City of Portland  
Development Review Application  
Planning Division Transmittal Form

**Application Number:** 2015-221                      **Application Date:** 12/09/2015  
**CBL:** 295 B001001                      **Application Type:** Level I Site Alteration  
**Applicant:** Poulin Property Holdings /Mark Poulin  
**Project Name:** Parking Expansion  
**Address:** 171 WARREN AVE  
**Project Description:** 5 paved parking spaces and stormwater treatment.  
**Zoning:** B4

Project Name: **Parking Lot Expansion- 5 additional spaces**  
Project ID: #2015-221  
Address: 171 Warren Avenue CBL: 295 B001001  
Applicant: Marc Poulin  
Planner: Jean Fraser

**Jean Fraser - RE: checking in - 171 Warren Ave - parking lot expansion**

PROJECT NUMBER: 32209 ACAD FILE: 32209-EXCONDIT PARKING.DWG SCALE: 1" = 20' DATE: DECEMBER 7, 2015

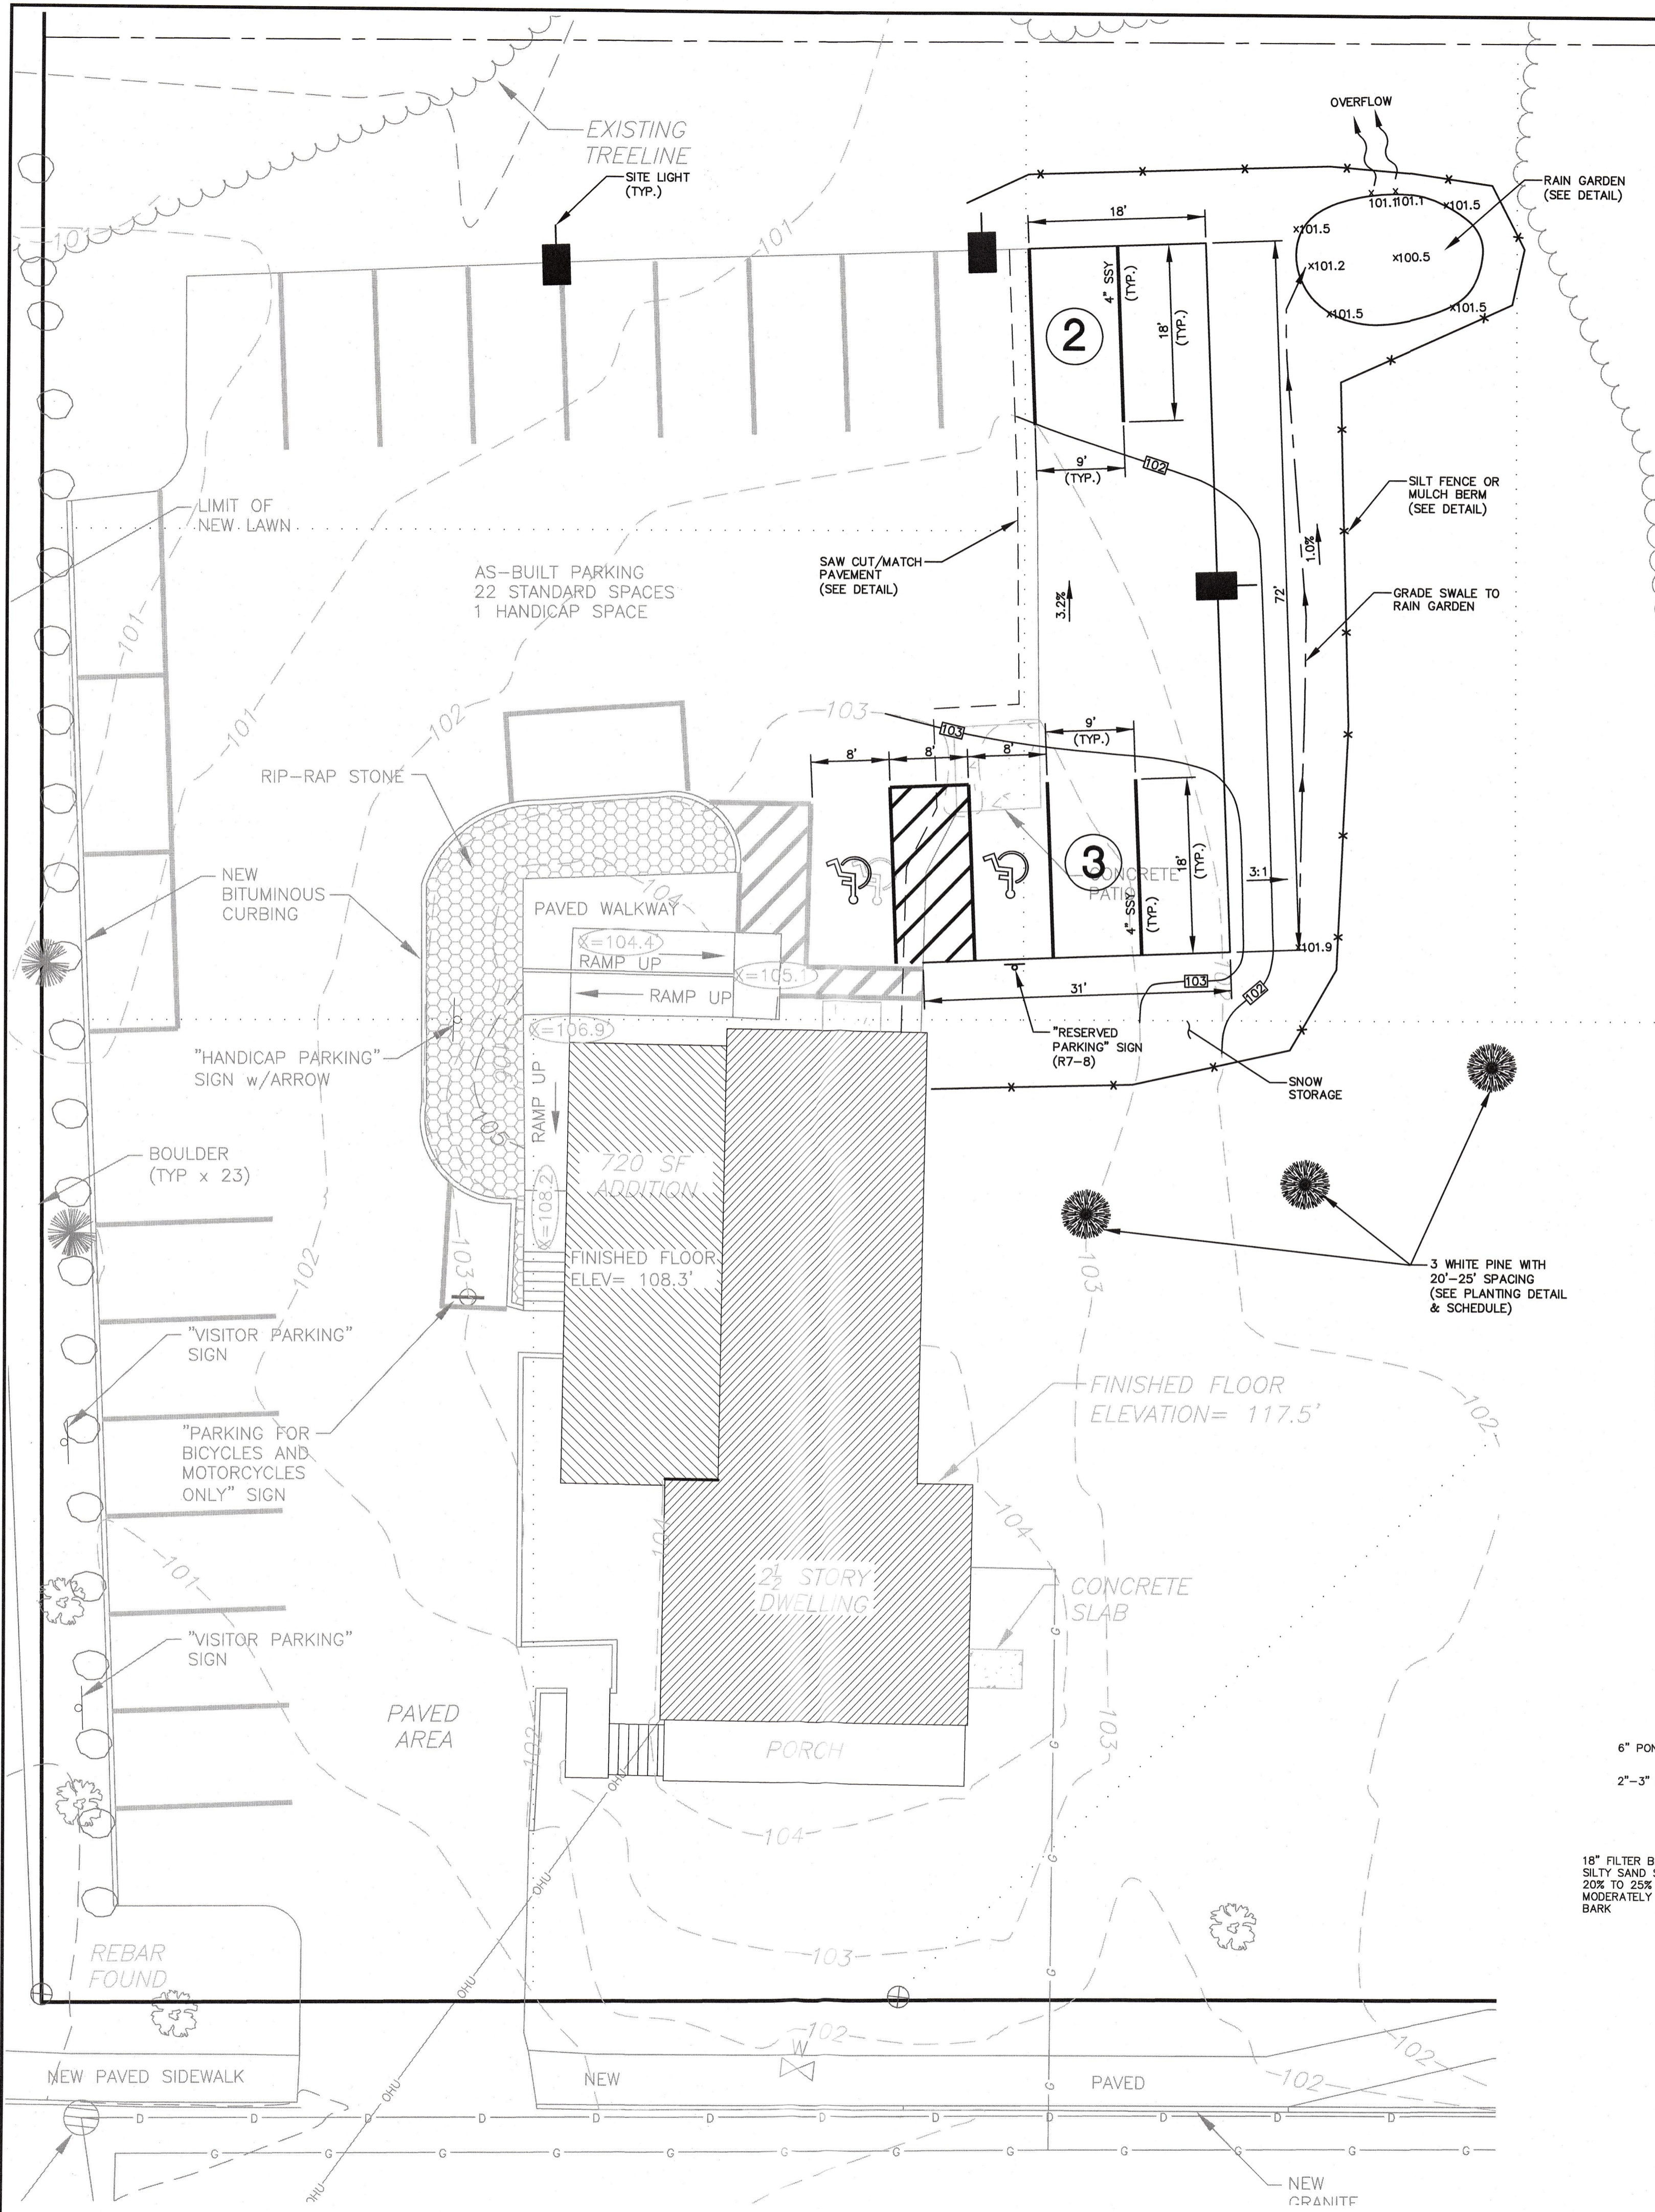
1. **Parking:** The site plan states that there is 3330 sq ft of offices in the building, and therefore the zoning requirement (per the ordinances) for this project would be 9 parking spaces (eg 1/400 sq ft)- which is what we originally approved. The Site Plan ordinance has this requirement (see underlined sections as most applicable):

So there are two questions: what is the correct office floorspace for your building (our assessors entries suggest its a lot more than 3330 sq ft); and if its less than 9200sq ft then there needs to be a narrative explaining why this much parking is needed.

2. **Landscape:** In a recent telephone conversation with you I advised that landscape screening of the new parking area should be included (screened from Warren). I don't see any landscaping screening on the site plan. The relevant ordinance is (see underlined section as most applicable- I have quoted the entire section for context):

3. **Bicycle parking:** The requirement for bicycle parking is 2 spaces for every 10 parking spaces, or 4 for this project. These need to serve both the employees and the visiting public. Could you confirm how many bike parking spaces you have now- and if this is less than 4 than some would need to be added.
